**RE: St. Peter and Paul Church, 5800 Ouray Road NW
Grading and Drainage Plan
Engineer's Stamp Date 4-16-2015 (File: H11-D062)**

**RE: St. Peter and Paul Church, 5800 Ouray Road NW
Grading and Drainage Plan
Engineers Stamp Date 3-20-2015 (File: H11-D062)**

This letter is in response to your comments by letter dated April 14, 2015. All of your comments have been addressed as follows:

C-101

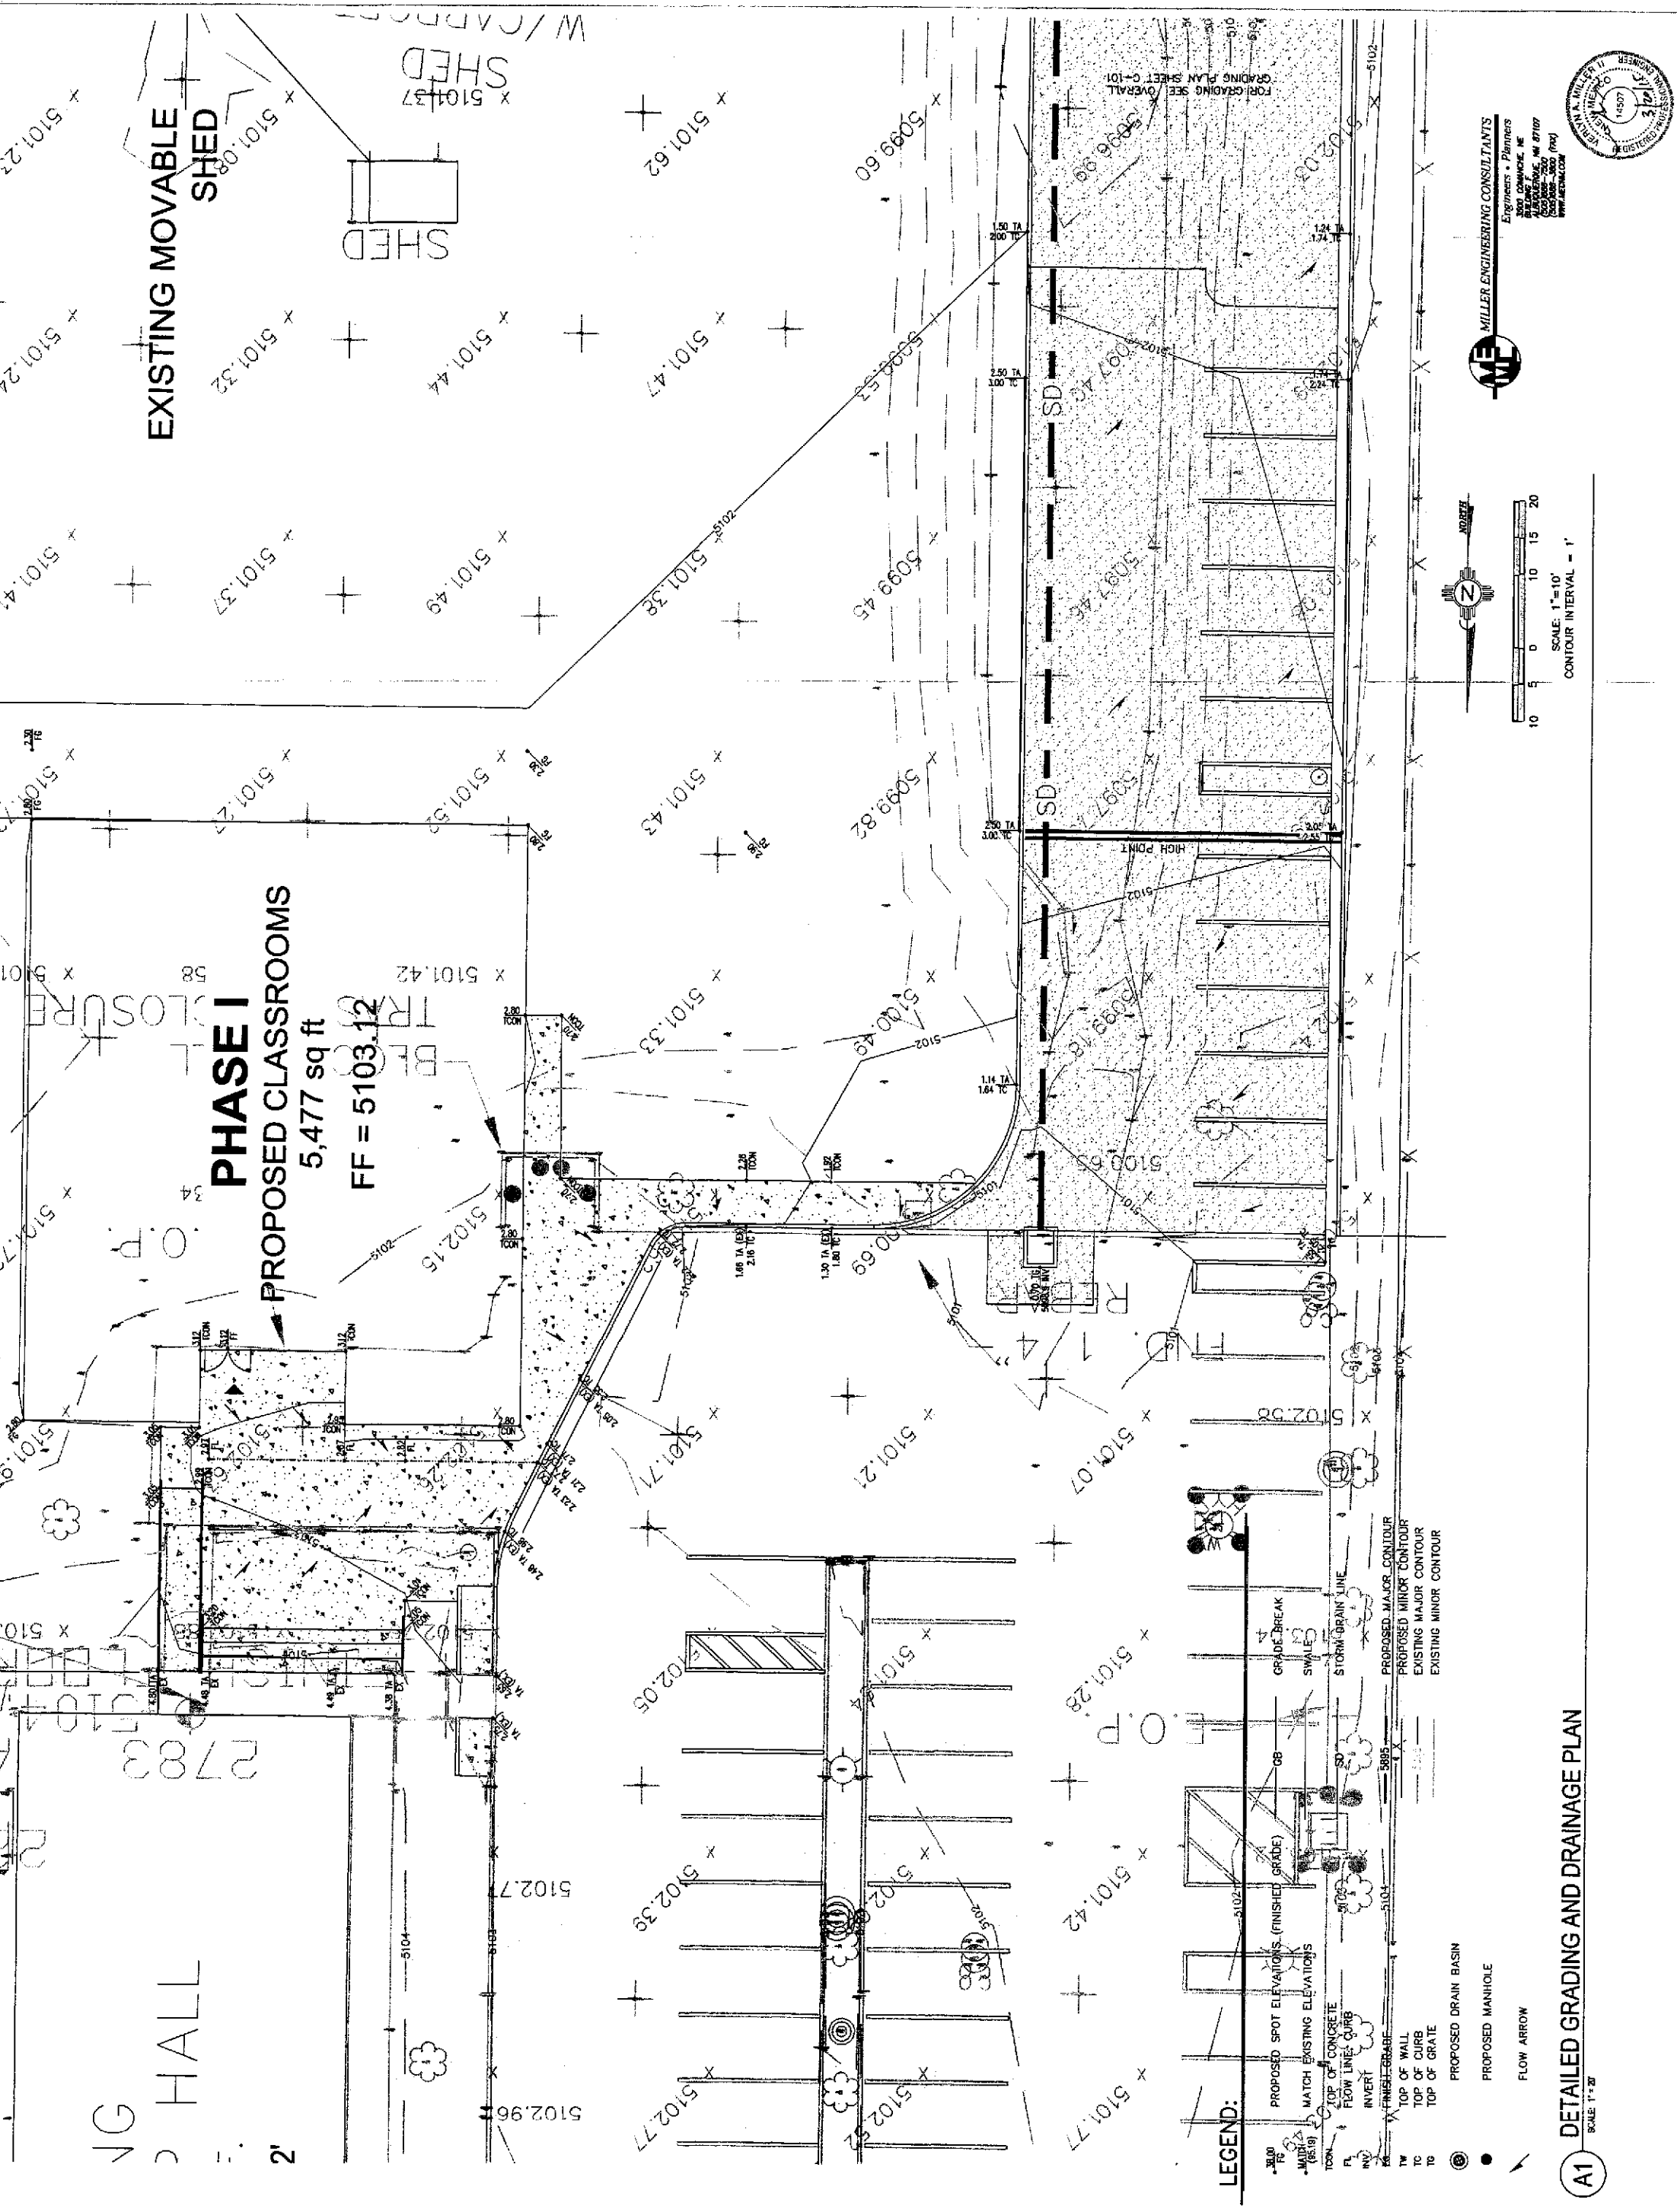
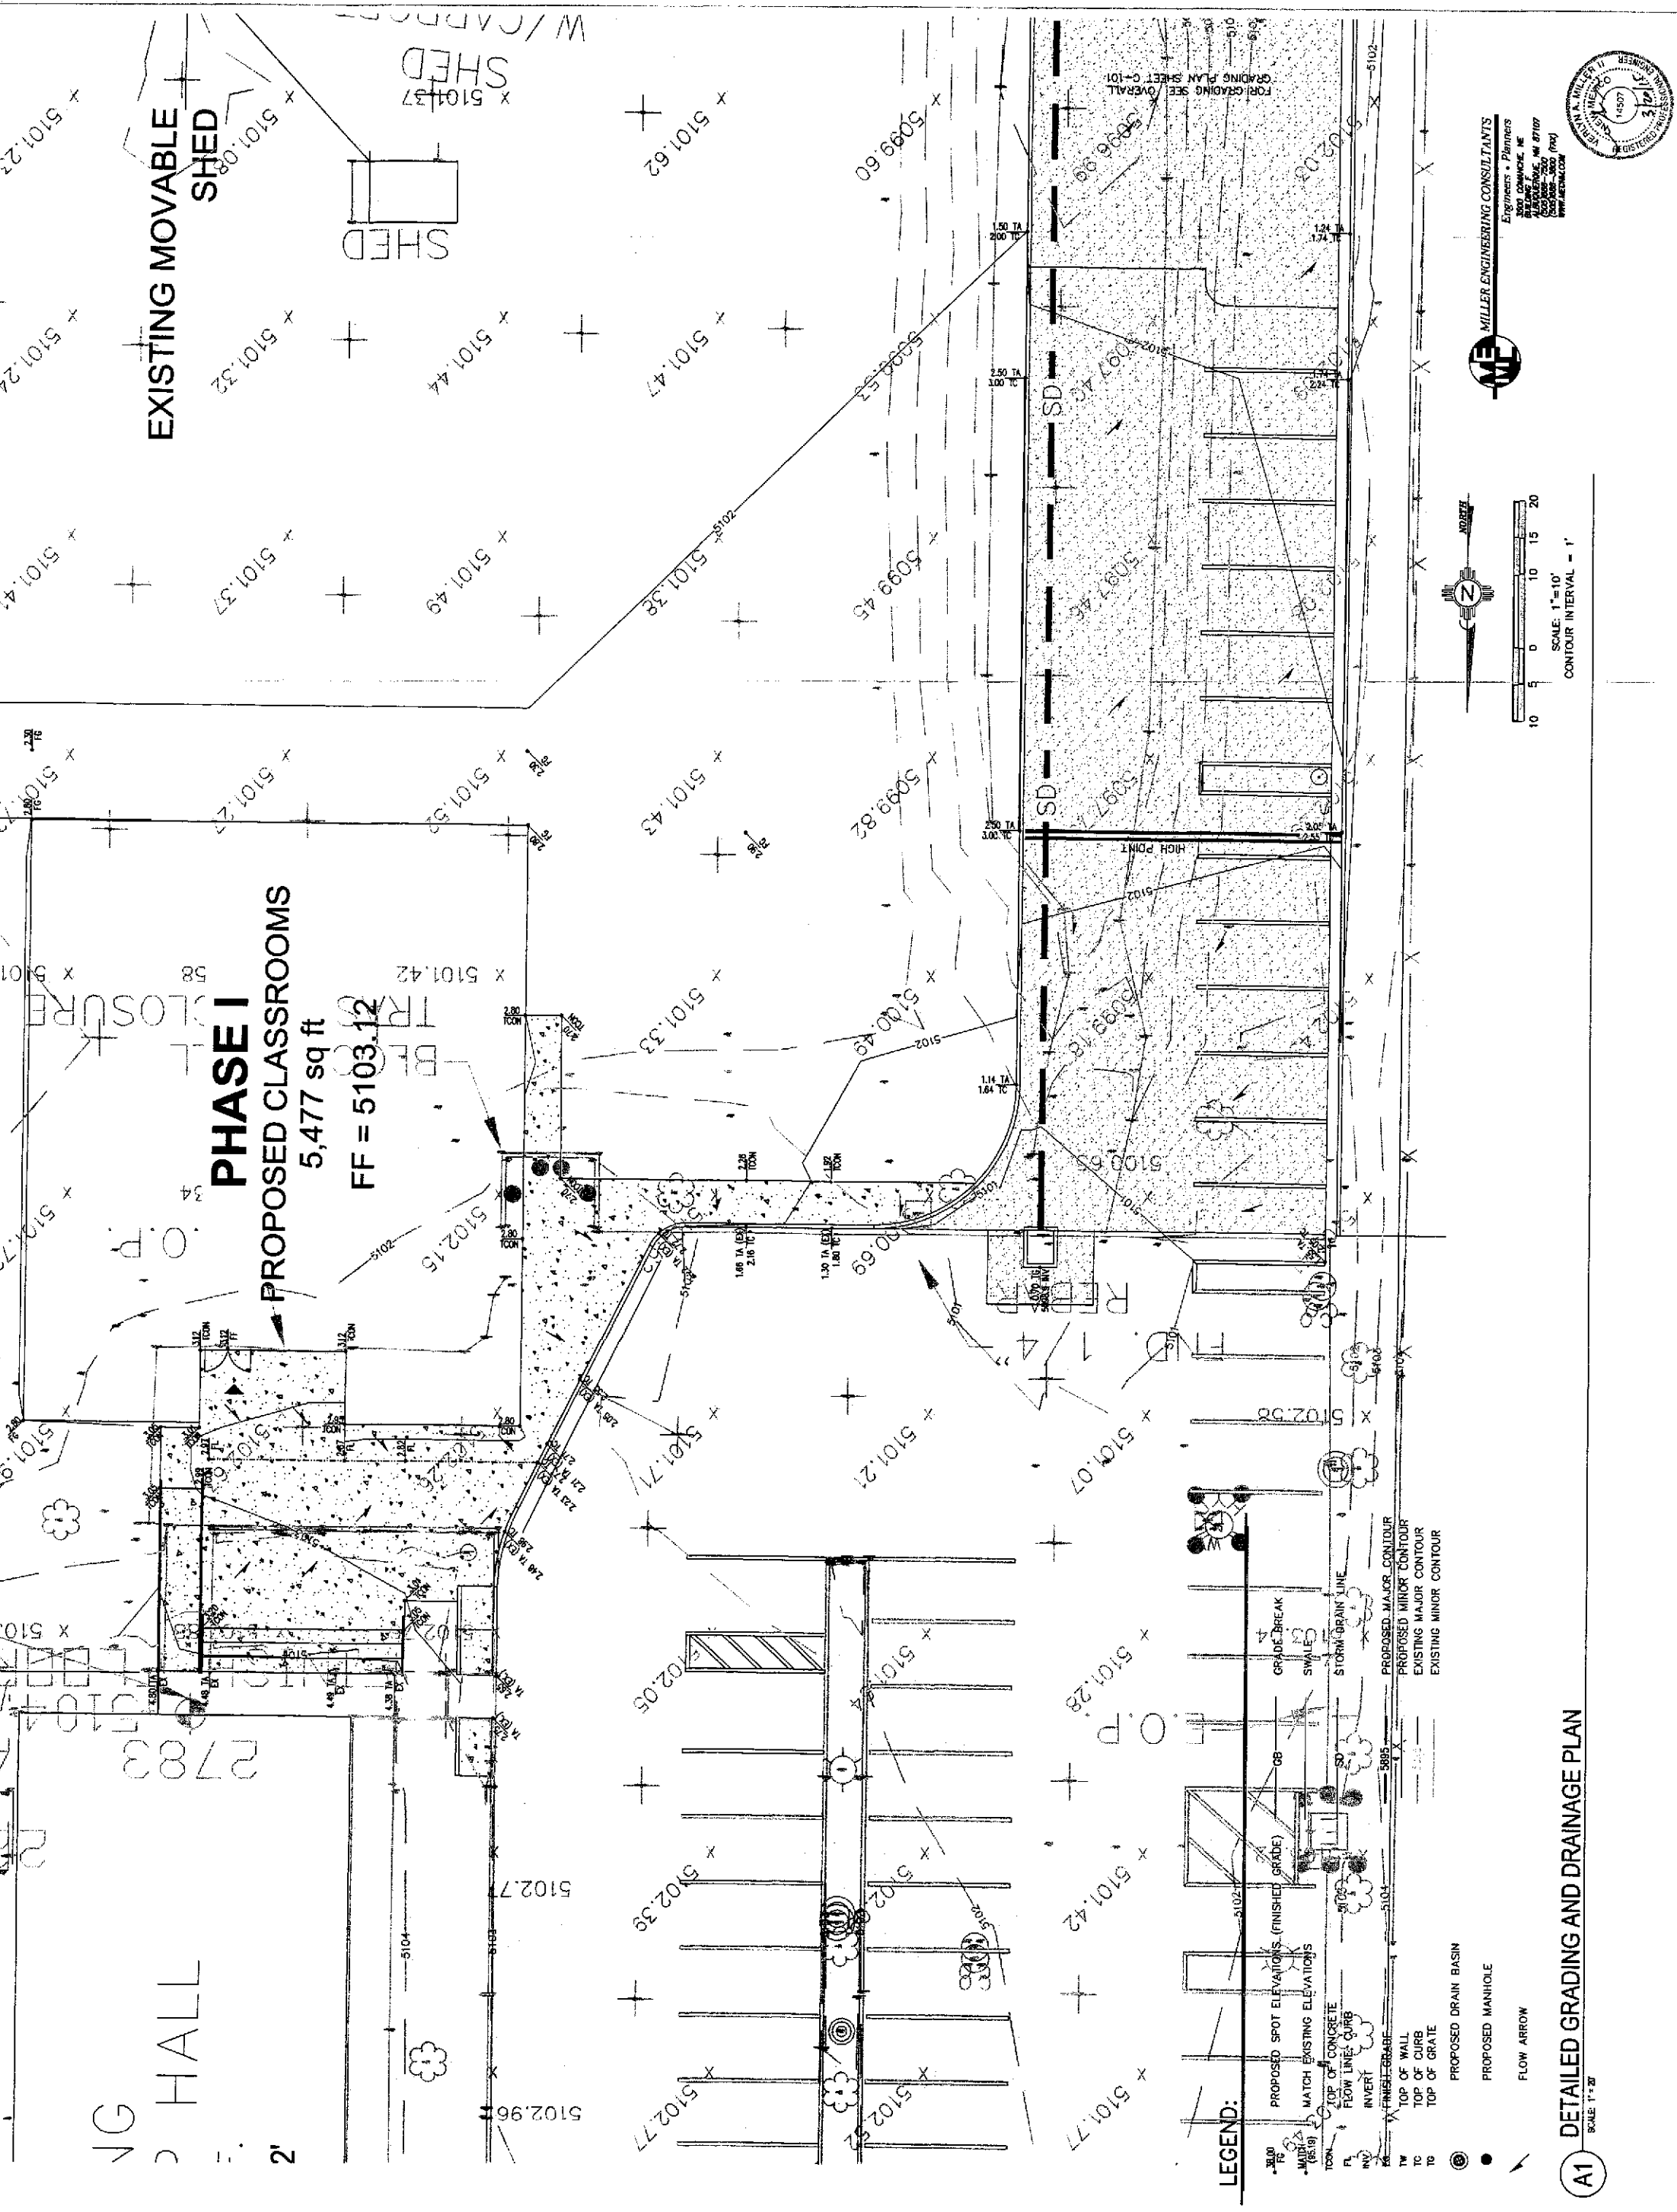
1. Highlight site on vicinity map, and show Basin A-1 and B-1 boundaries. In the Drainage Narrative, explain Basin A-1's ultimate discharge to the southwest corner of the property if this is the case.
Please see sheet c-100 for highlighted vicinity map. Please see sheet C-101 for the drainage basin boundaries. Please see c-100 under the conclusion for the description of Basin A-1 ultimate discharge to SW corner of property.

2. In discussion of off-site flows, also mention any impact of on-site drainage to the property to the west and east or lack there-of. Provide more existing spot elevations along the western and eastern boundaries of the site.
Please see c-100 under the off-site flows for impact of onsite flows to offsite properties. Please see c-101 for additional existing spot elevations.

3. For the new 12" pipe tie-in to the existing inlet at the southwest corner of the site, provide a downstream invert elevation and show the invert elevation of this existing inlet to ensure positive flow to the storm drain in Miami Road. Show and label existing storm drain in Miami Road and the tie to the existing storm drain in Miami Road.
Please see sheet C-101, for the information on the onsite existing storm drain inlet and the location of the offsite storm drain system.

4. Label curb cuts where needed in low spots within the newly paved areas. It looks like a curb cut needs to be called out where Keyed Note 13 calls out a riprap rundown from the parking lot.

5. Keyed Note 17 for the storm drain is not called out on the plan view.
Please see Sheet C-101 for the key note call out.
6. Is the top of grate elevation meant to be called out as 5100.70 on Keyed Note 16? If so, call it out, and double check on pipe cover since with the listed pipe invert elevation, it appears that the pipe cover is less than a foot.
Please see Sheet C-101 and C-102 for revised elevations.
7. Show capacities, discharge flows, and pipe slopes for all proposed on-site storm drain pipes. Show capacity of new on-site inlet. For any proposed curb cuts, also provide capacity calculations.
Please see attached hydraulic calculations for the capacity calculations.
8. For the proposed pond, label complete pond volume and WSEL Elevation.
Please see Sheet C-101 for additional pond information.

Please see Sheet C-101 for the curb cut call out.
